02 February 2022

OBJECTION - HORSLEY DRIVE BUSINESS PARK – STATE SIGNIFICANT DEVELOPMENT APPLCIATION 17161650

EXHIBITION OF EIS - HORSLEY DRIVE BUSINESS PARK STAGE 2 BUILDINGS 2 & 3 - CNR COWPASTURE ROAD & TRIVET STREET, WETHERILL PARK

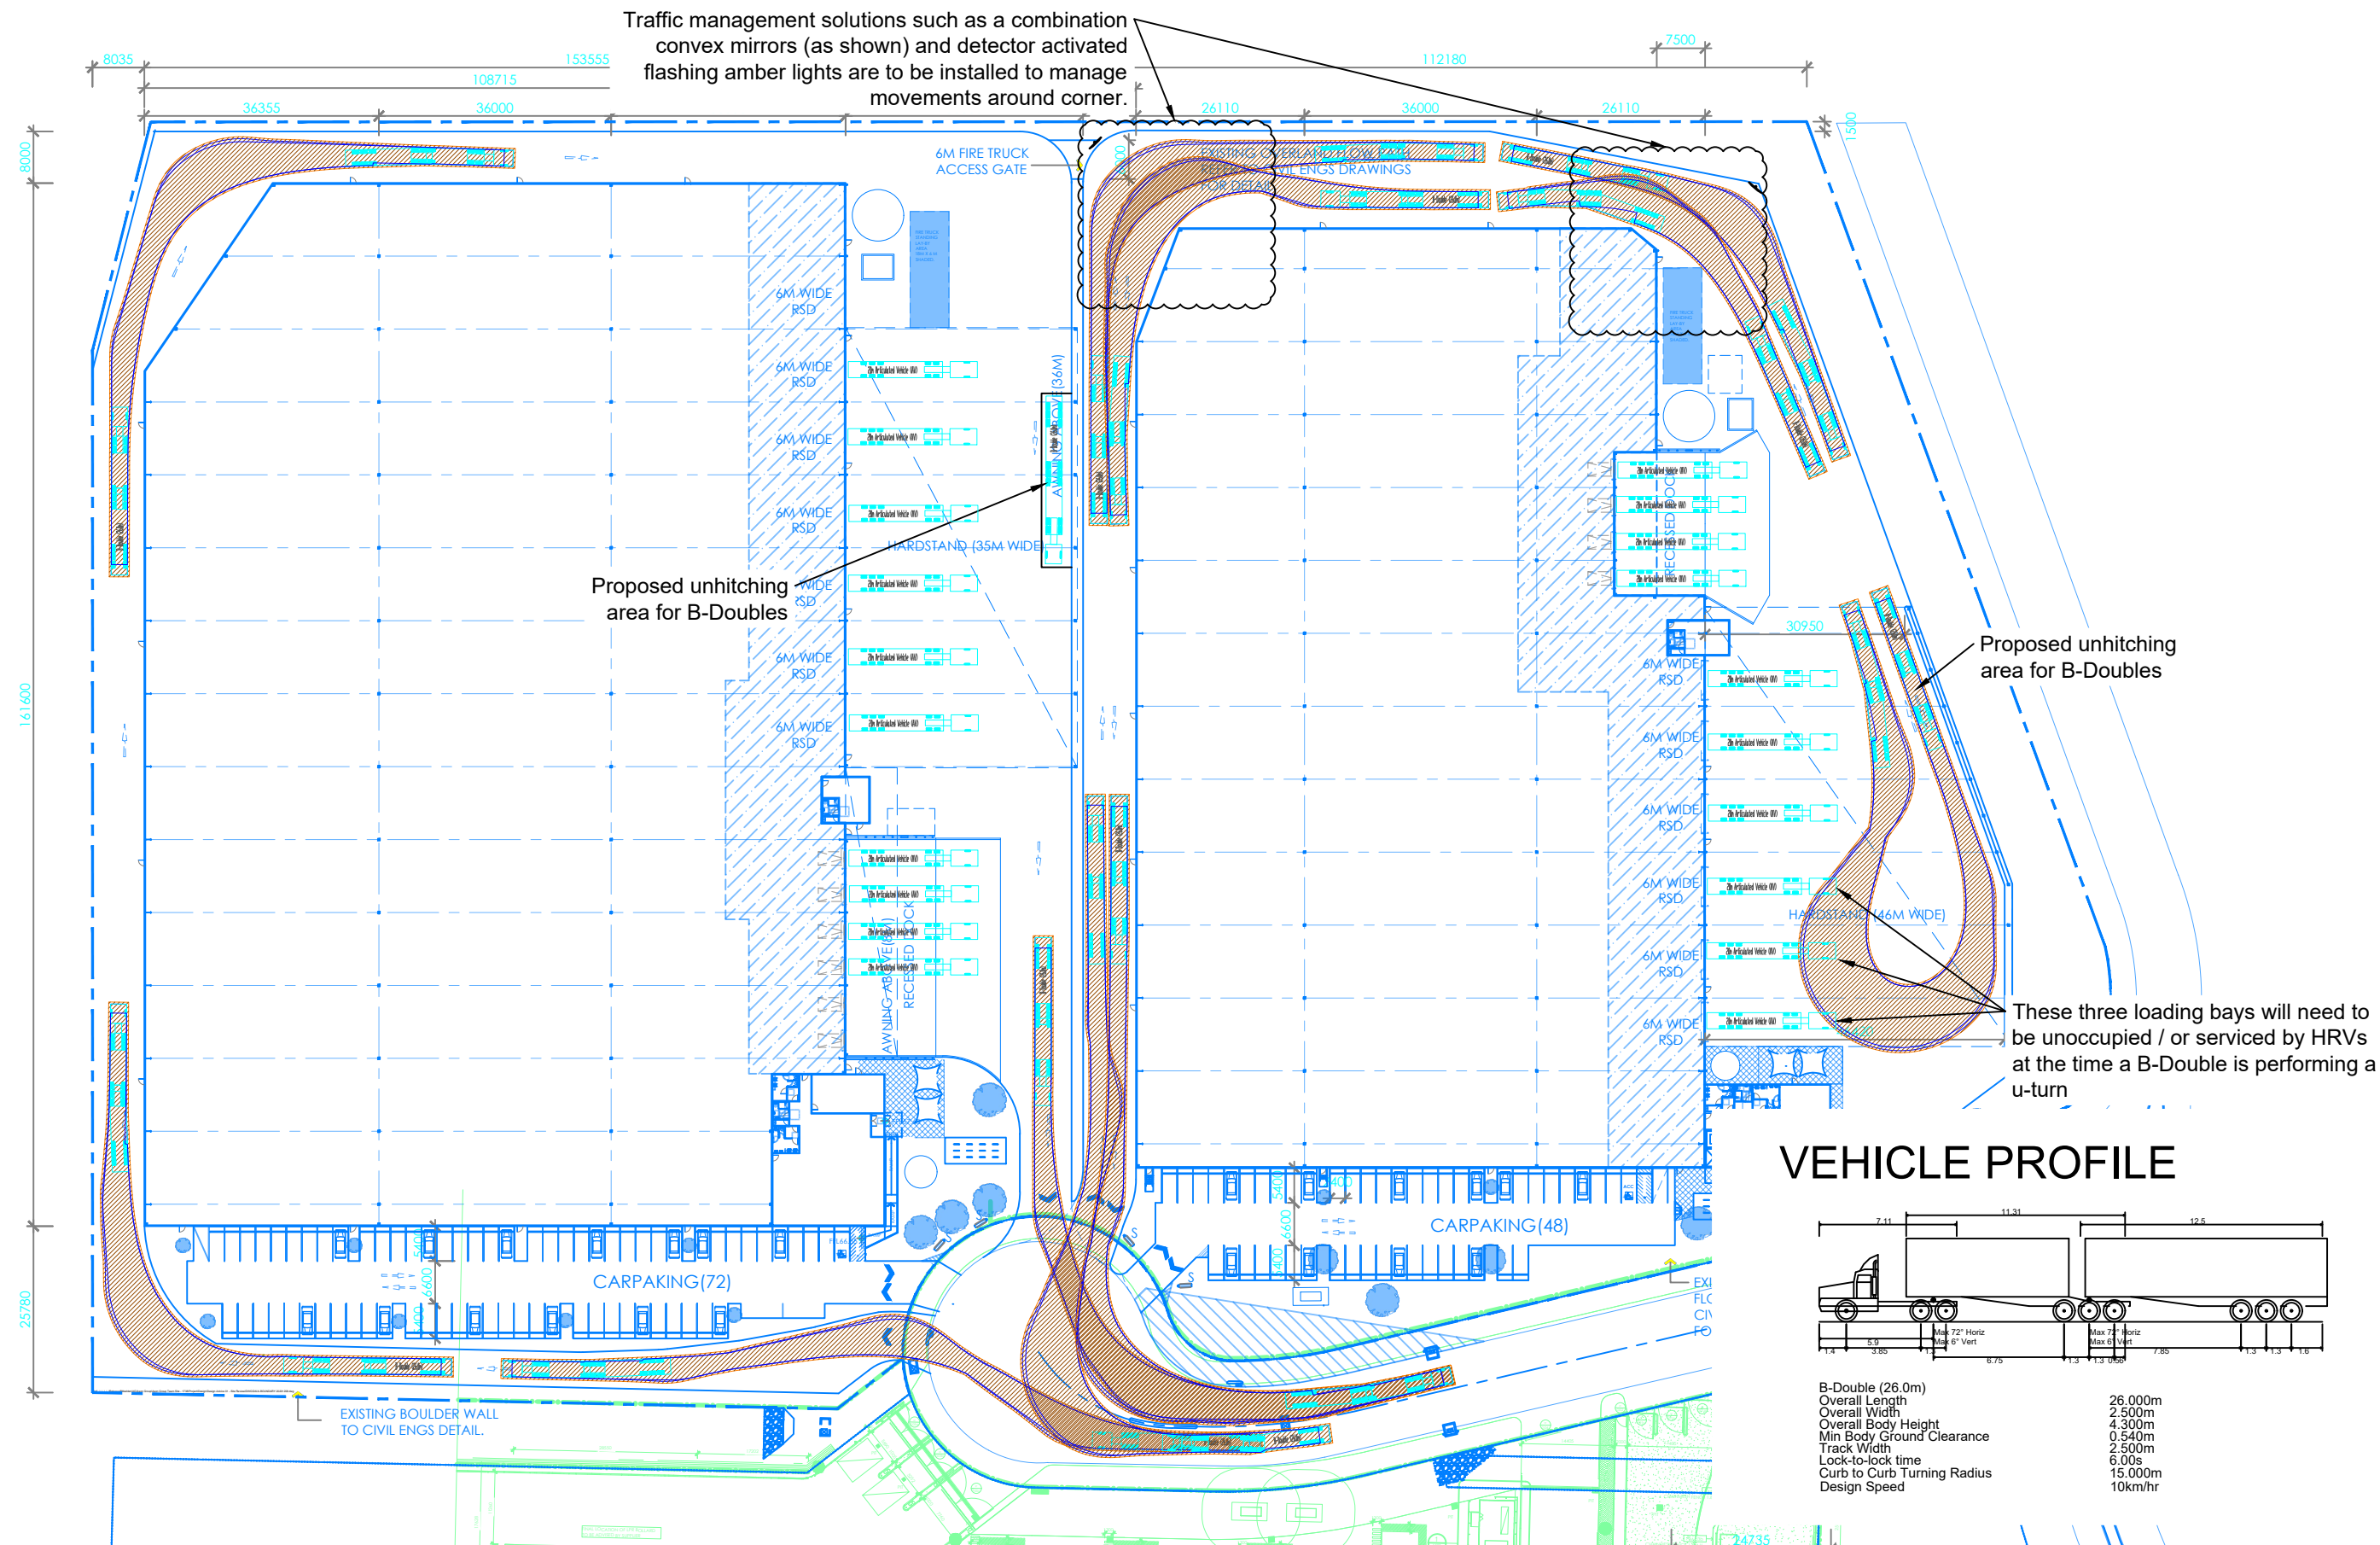
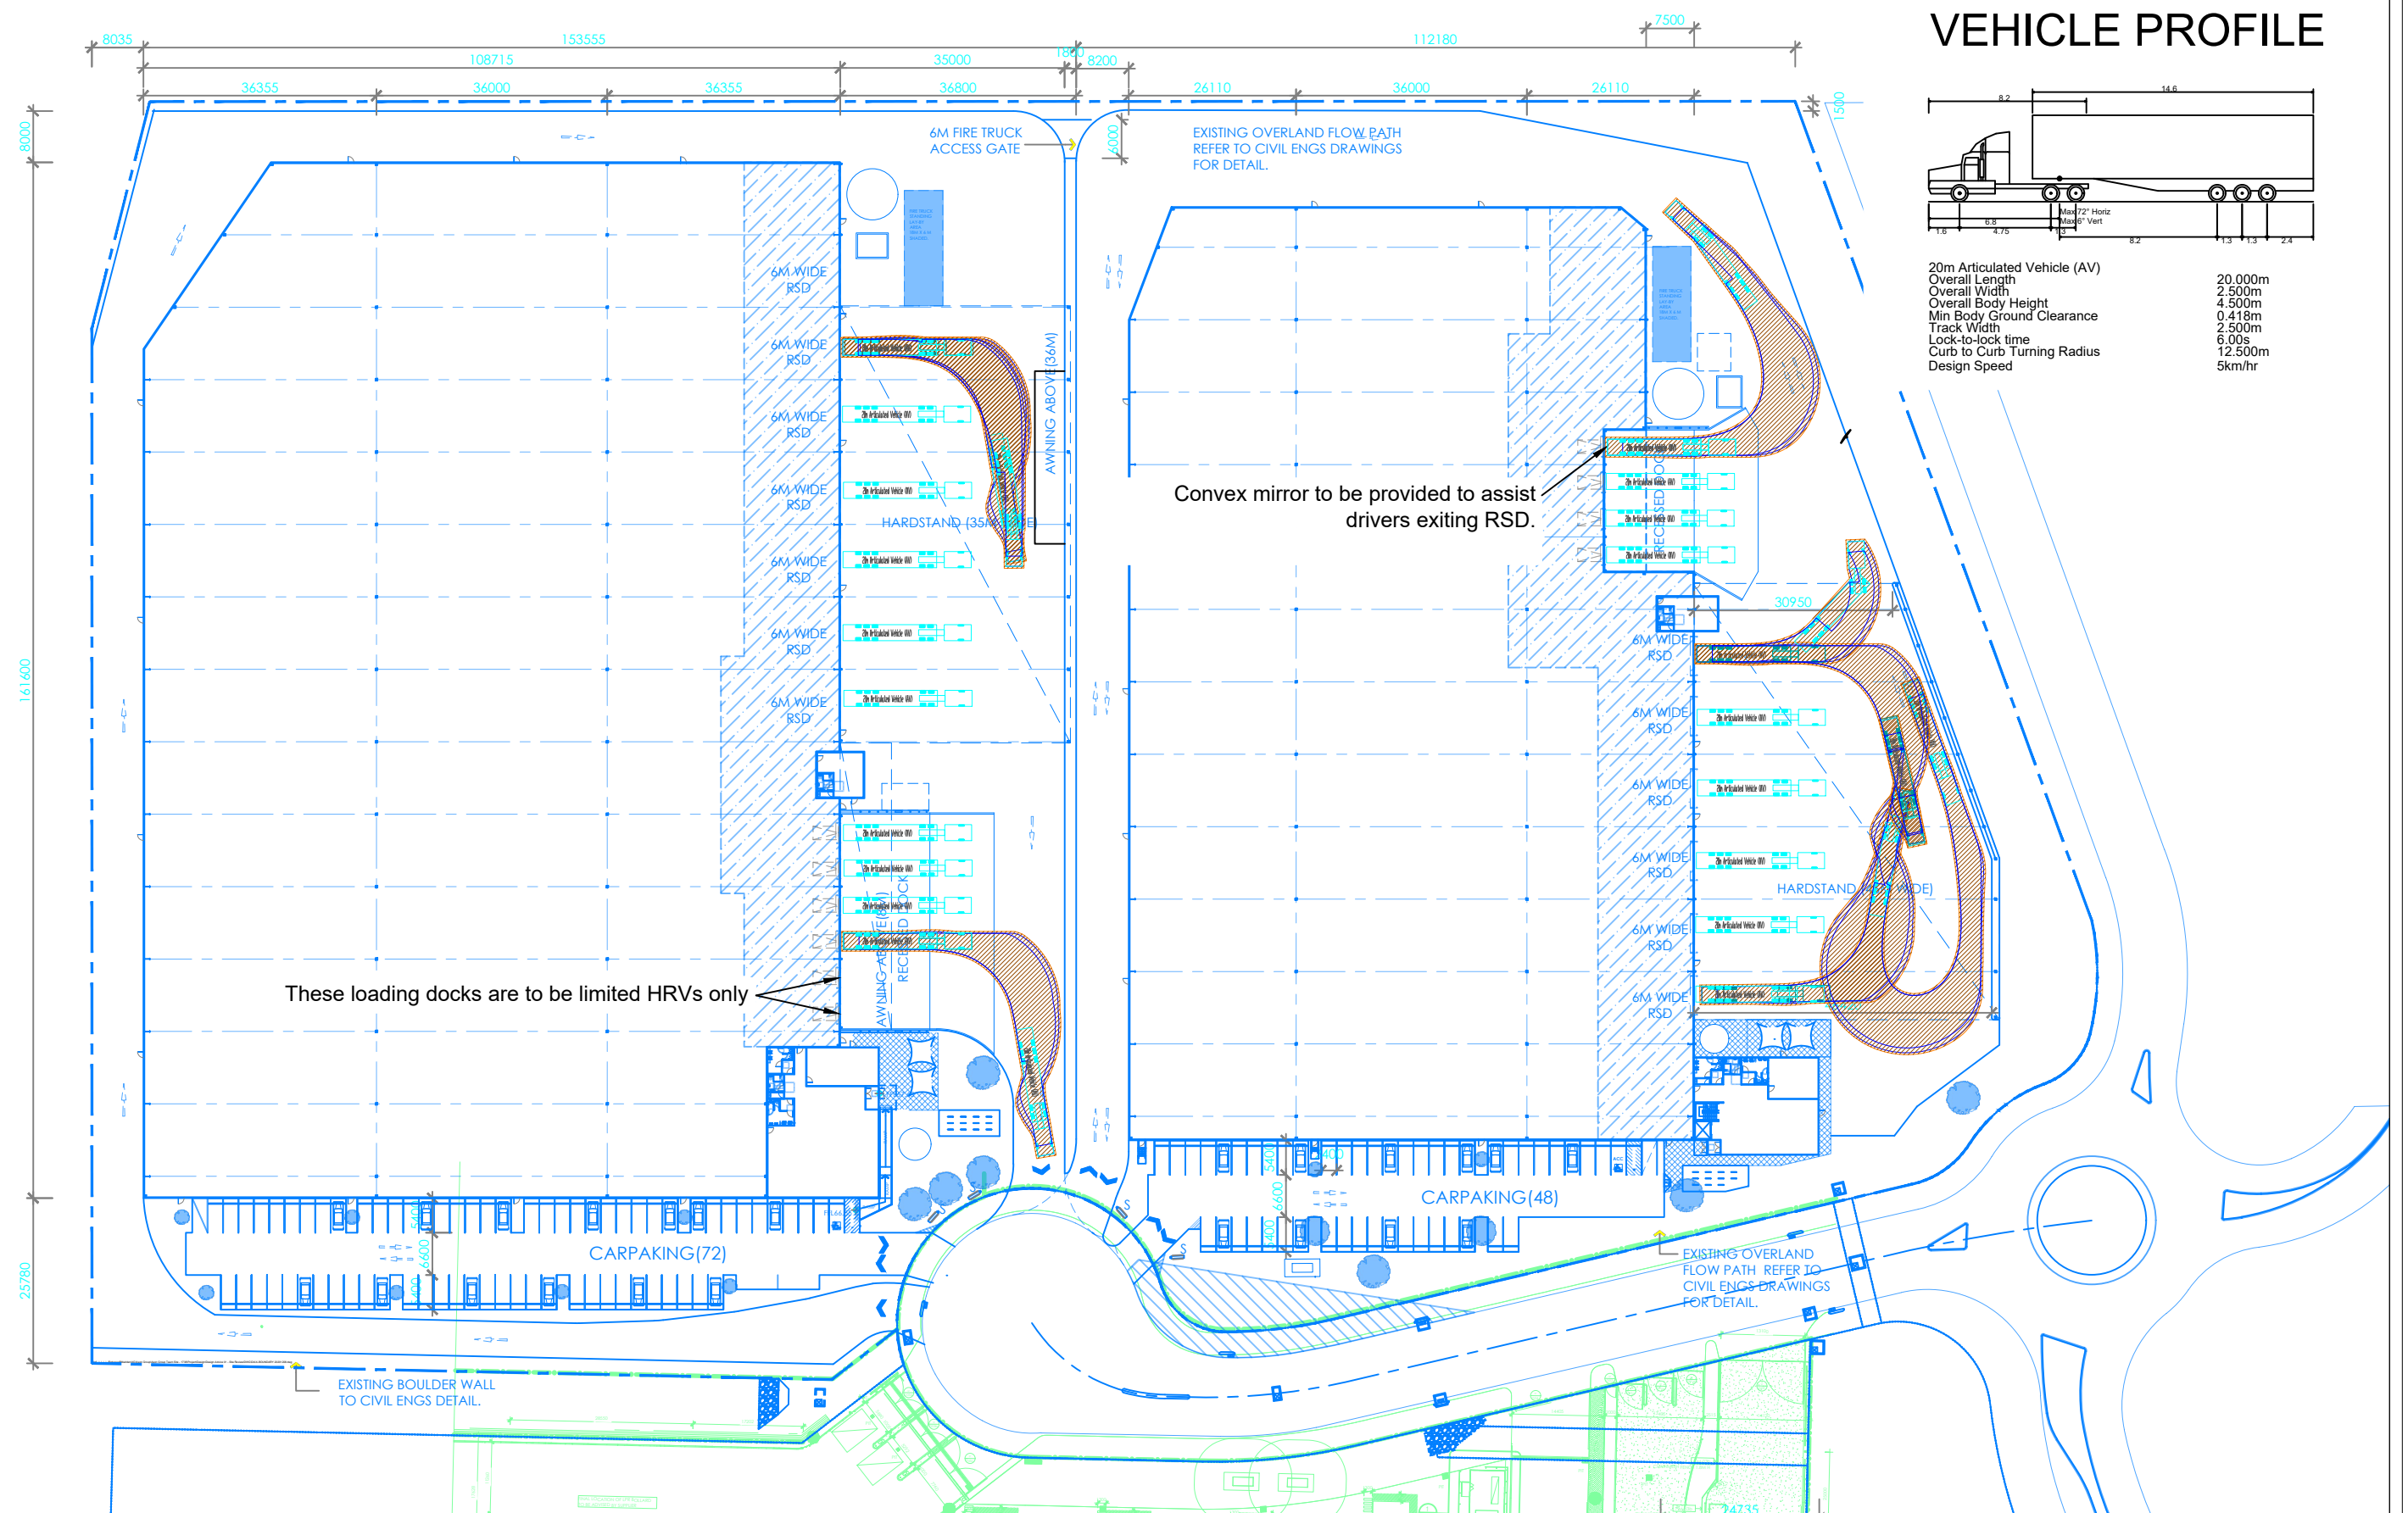
- a. The applicant's OTMP shows, Warehouse 3 is expected to generate 24 vehicle movements (with 7 heavy vehicle movements i.e. 3-4 trucks are anticipated) during the AM and PM peak hours. Based on the applicants' swept path diagrams, the site in its current form would not have the capacity to support the simultaneous movements of 26m B-Double trucks and another vehicle at/near the driveway areas and at the intersections within the site. Where two-way traffic flows are not feasible, the installation of restrictions to allow one-way traffic flow shall be considered.

- c. The swept path analysis shows that it would be difficult for 25m/26m B-Double vehicles to exit the site (turning left out of the site) onto the Estate Road without crossing the Centre of the road particularly with the worst-scenario where vehicles are parking on the Estate Road at/near the site. In this respect the site layout and access arrangement are not satisfactory. Based on the swept path analysis, the development proposal would impact on the surrounding road network's traffic operations and road safety.

- a. The truck exit point for Warehouse 2 and Combined Entry / Exit for Warehouse 3 are too close and likely to create confusion to the truck drivers servicing the sites. The access points need to be separated with adequate distance to enable safe entry and exit from the sites.
- b. The B-Double trucks shown at the loading docks at Warehouse 3 appear to encroach onto the manoeuvring areas. The truck manoeuvring areas shall be clear of loading unloading areas.
